Your Ref: OWPC5057
Our Ref: FG/180/14/L 09-12-2014
Please ask for:
Mrs A Gardner

Planning (Listed Buildings and Conservation Areas) Act 1990 (as amended)
Planning (Listed Buildings and Conservation Areas) Regulations 1990 (as amended)

Application for Listed Building Consent for retention of replacement sash windows
Bramble Cottage 50 Sea Lane Ferring

SITE AND LOCATION PLAN

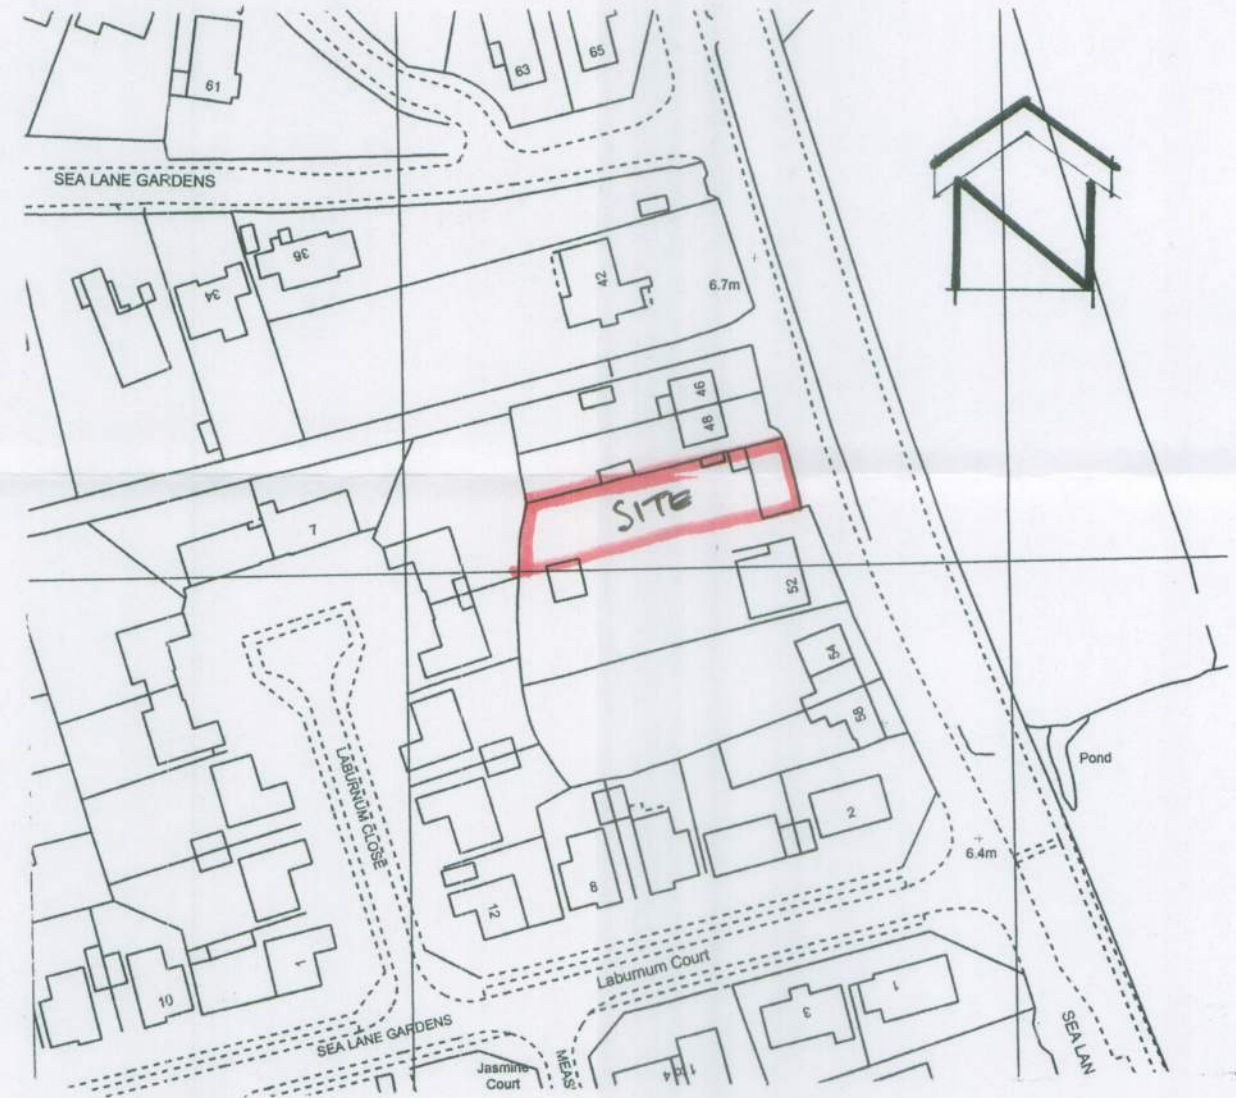
The site and location plan - 02, together with the Block Plan are both incorrectly defined. The applicant has incorporated a large part of my garden into the site plans. For the sake of clarity, I suggest that both of these plans are rectified as soon as possible to show the applicants actual boundary. Denise Jenkins
